From: Simmons, Maxine
Sent: 28 October 2024 15:58
To: _planningadvice
Subject: FW: Home Farm - Urgent - please process as an amendment.
Attachments: We sent you safe versions of your files; LDC4244-102G.pdf; LDC4244-104A.pdf; LDC4244 IPS Rev.C.pdf; LDC4244 Planning Amendment Form.pdf

From: Ricky Newton <ricky@lincsdesignconsultancy.co.uk>
Sent: Monday, October 28, 2024 9:59 AM
To: Simmons, Maxine <Maxine.Simmons@sholland.gov.uk>
Subject: RE: Home Farm

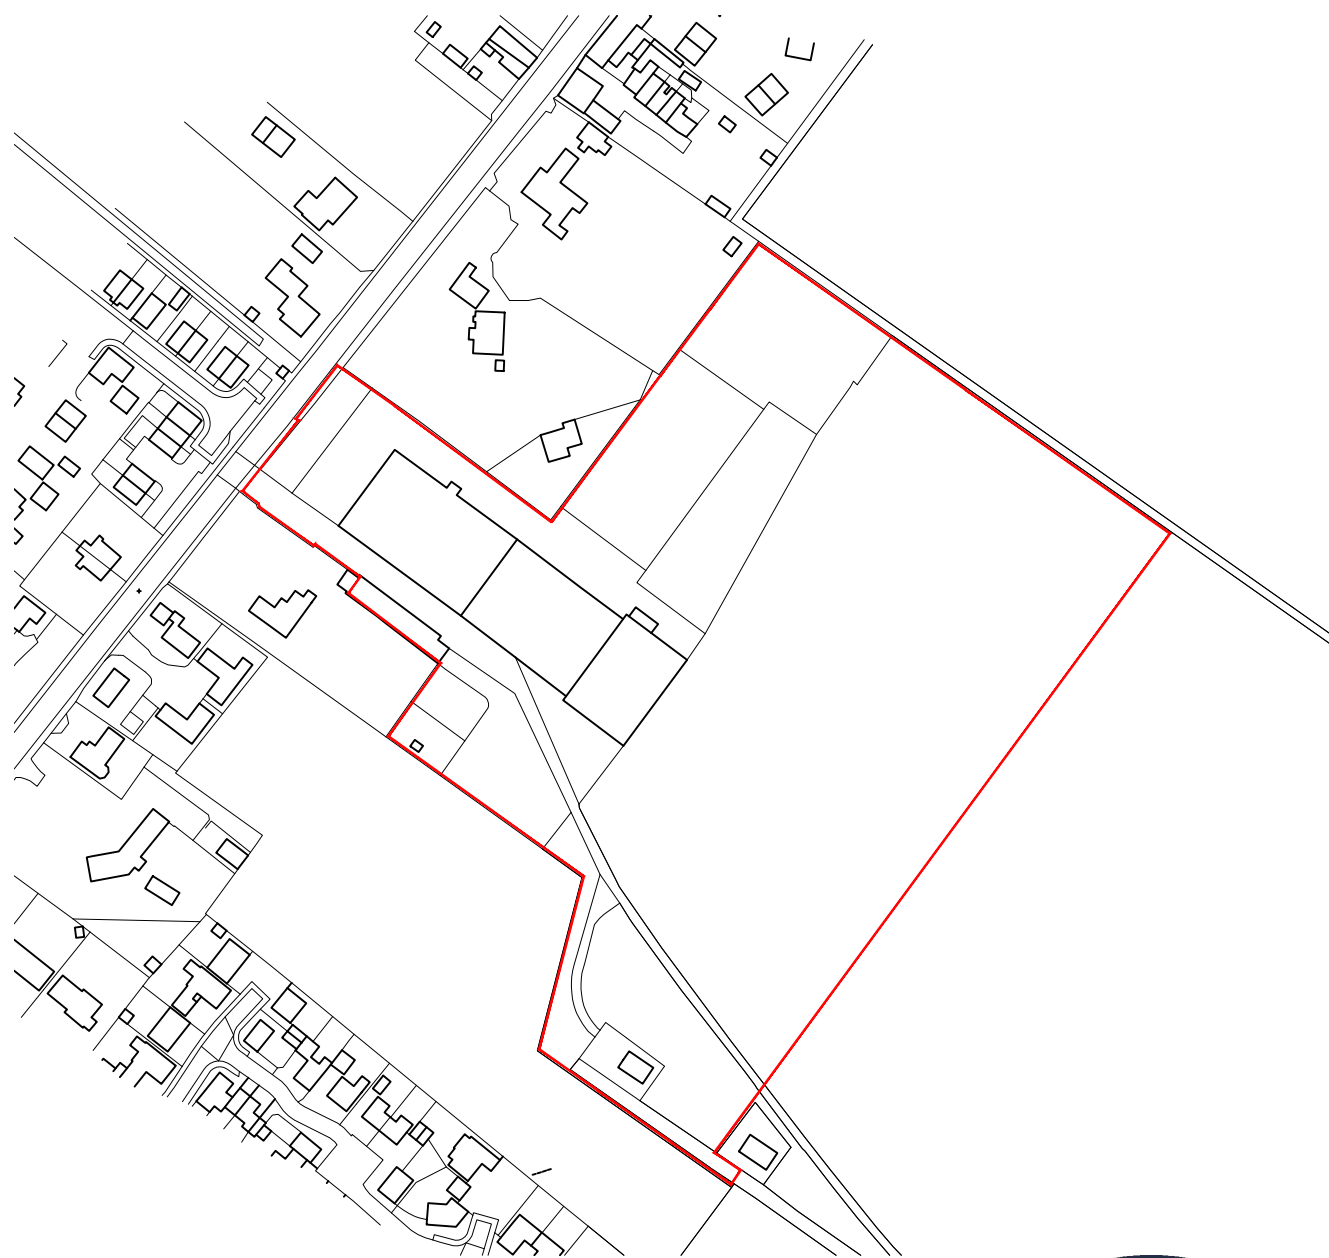
This is fine, can we stick three large trees at the back of the attenuation pond as compensatory trees at the back?

Hi again, it's the loss of these trees along the front that I've got a problem with. Can you incorporate ANY of these into the layout?

- The trees to the front of the village hall have been retained where possible. We have lost 2no trees but have retained the willow, sycamore and horse chestnut. The existing hedge to the sites frontage will also be retained. All of which has been labelled on the plan. As discussed, I am happy to accept a pre-commencement condition for a tree protected plan and Method Statement to be provided.
- To address the retention of the trees the car park has been rejigged with spaces provided to the north east of the hall.
- 2no large replacement trees have been located in the public open space to mitigate the loss of the 2no trees to the sites frontage.
- We have updated the landscaping plan to reflect he changes to the scheme. The proposed tree species are all native and are taken from the highways suggested tree list.
